PORTISHEAD BRANCH LINE (METROWEST PHASE 1) DEVELOPMENT CONSENT ORDER

DRAFTING NOTE ON THE SECRETARY OF STATE'S "MINDED TO" DRAFT DCO

Drawn
COMPOUNDS, HAUL ROADS, AND ACCESS TO WORKS PLAN SHEET 1 PORTISHEAD

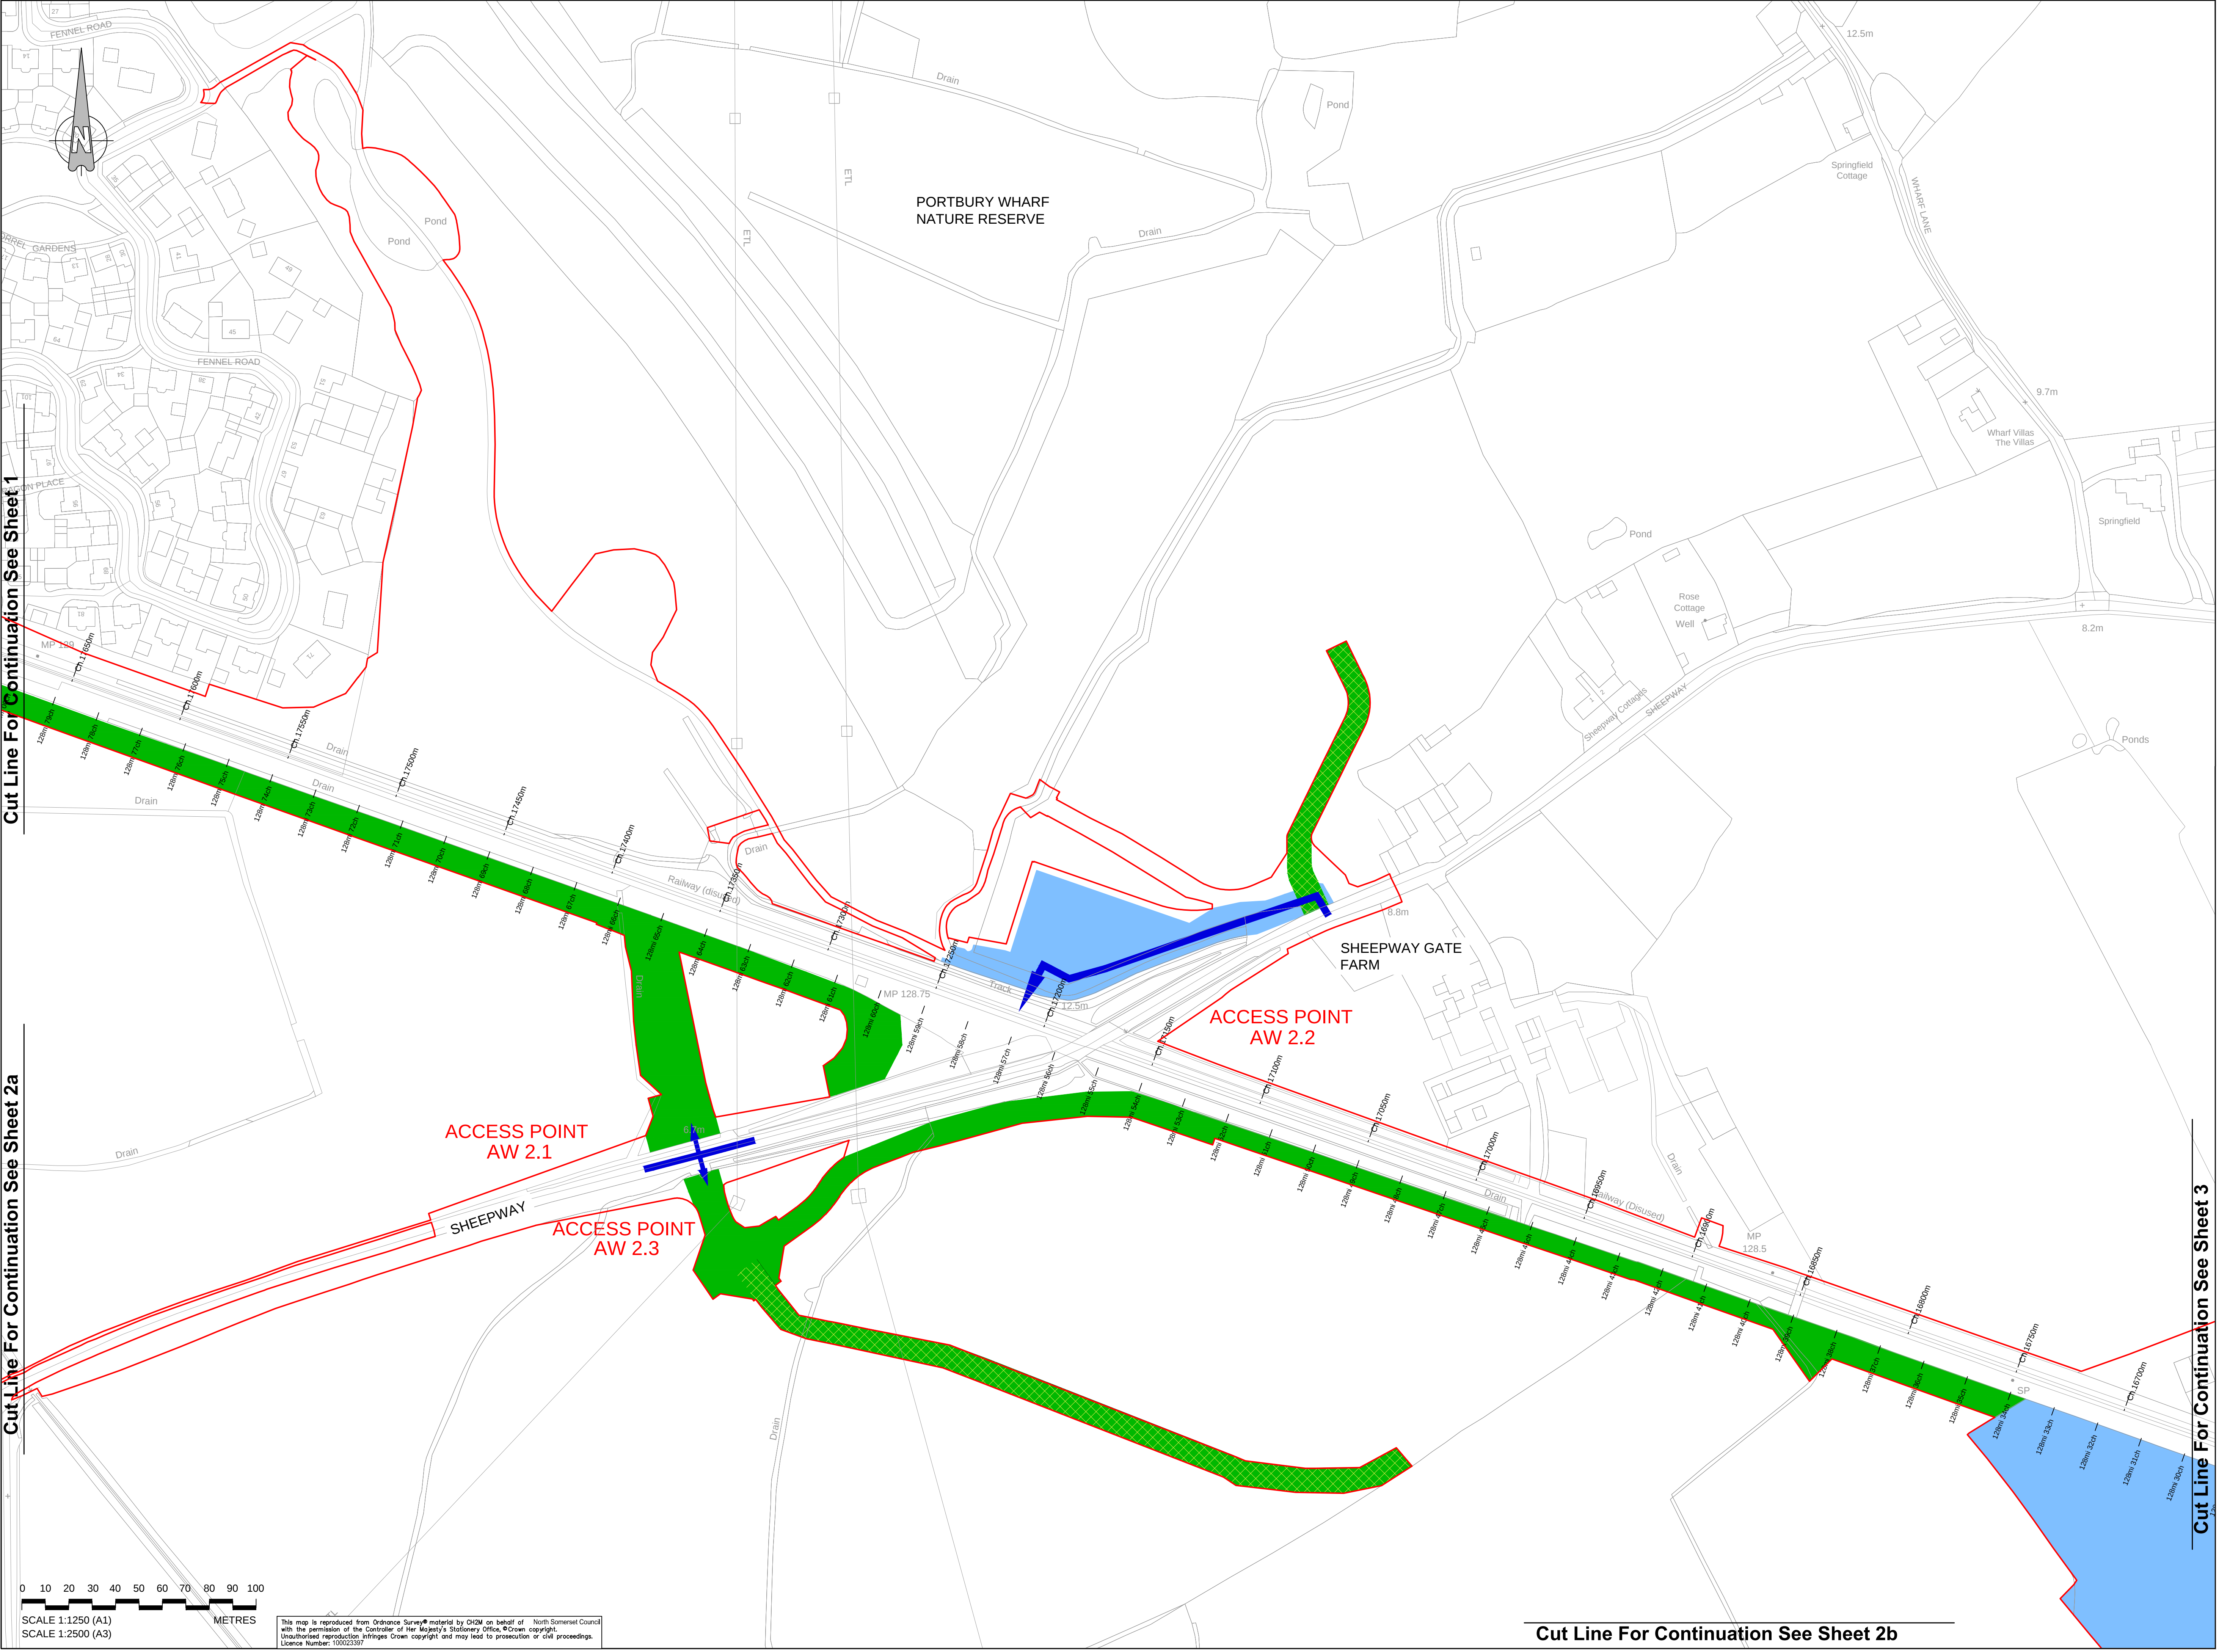
2.9 The changes made to DCO Requirement 30, in particular that “.....[to show the proposed levels for the flood compensation mitigation area to be 7.3m AOD.....](#)”, are a major concern as a level of 7.3m AOD may not be achievable.

2.10 The current ground level is 7.5m AOD and the Applicant proposed to lower the level to 7.4m AOD. Lowering the level by a further 10cm to 7.3m AOD presents a number of challenges:

(a) There are a number of utilities located within this site including; a culverted watercourse, surface water drain/sewer and a foul sewer. These all need to have sufficient depth below ground according to the relevant technical requirements of the utility company owners. The

utilities will require protection measures over the top of apparatus and the need to maintain a minimum depth below ground level for the buried apparatus. This is particularly the case in the context of the Applicant's proposed use to operate HGV low loaders within the compound.

- (b) Lowering the land by a further 10cm will affect the Applicant's proposed ramp design, given the change from the ground level to the track level. Lowering the land by a further 10cm will result in either the length of the ramp being increased or the gradient of the ramp being increased. Lengthening the ramp is problematic because there may not be sufficient space while retaining the ability to operate a HGV low loader, given the constrained site size. Increasing the gradient of the ramp is problematic as that may not accord with engineering and safety design standards.

- (c) Lowering the land by a further 10cm could cause the compound to be water logged for periods of time which could have a detrimental impact on the usability of the compound for Network Rail. This could be problematic as Network Rail need to have the ability to use this compound/ access point at all times for the safe operation of the railway, to respond to any incidents arising on the railway.

- 2.11 The modified Requirement 30 text proposed by the ExA and Secretary of State could present major deliverability challenges for the Applicant.
- 2.12 We believe there may be other design solutions available, that would not necessarily involve lowering the ground to 7.3m AOD, but still achieve the required flood storage capacity.

- 2.13 These alternative solutions can be explored during the detailed design stage which is scheduled to commence in the coming months, in consultation with the relevant planning authority and the Environment Agency. Requirement 30(3) has been amended to provide for alternative design solutions in a mark up of the Order accompanying this note.
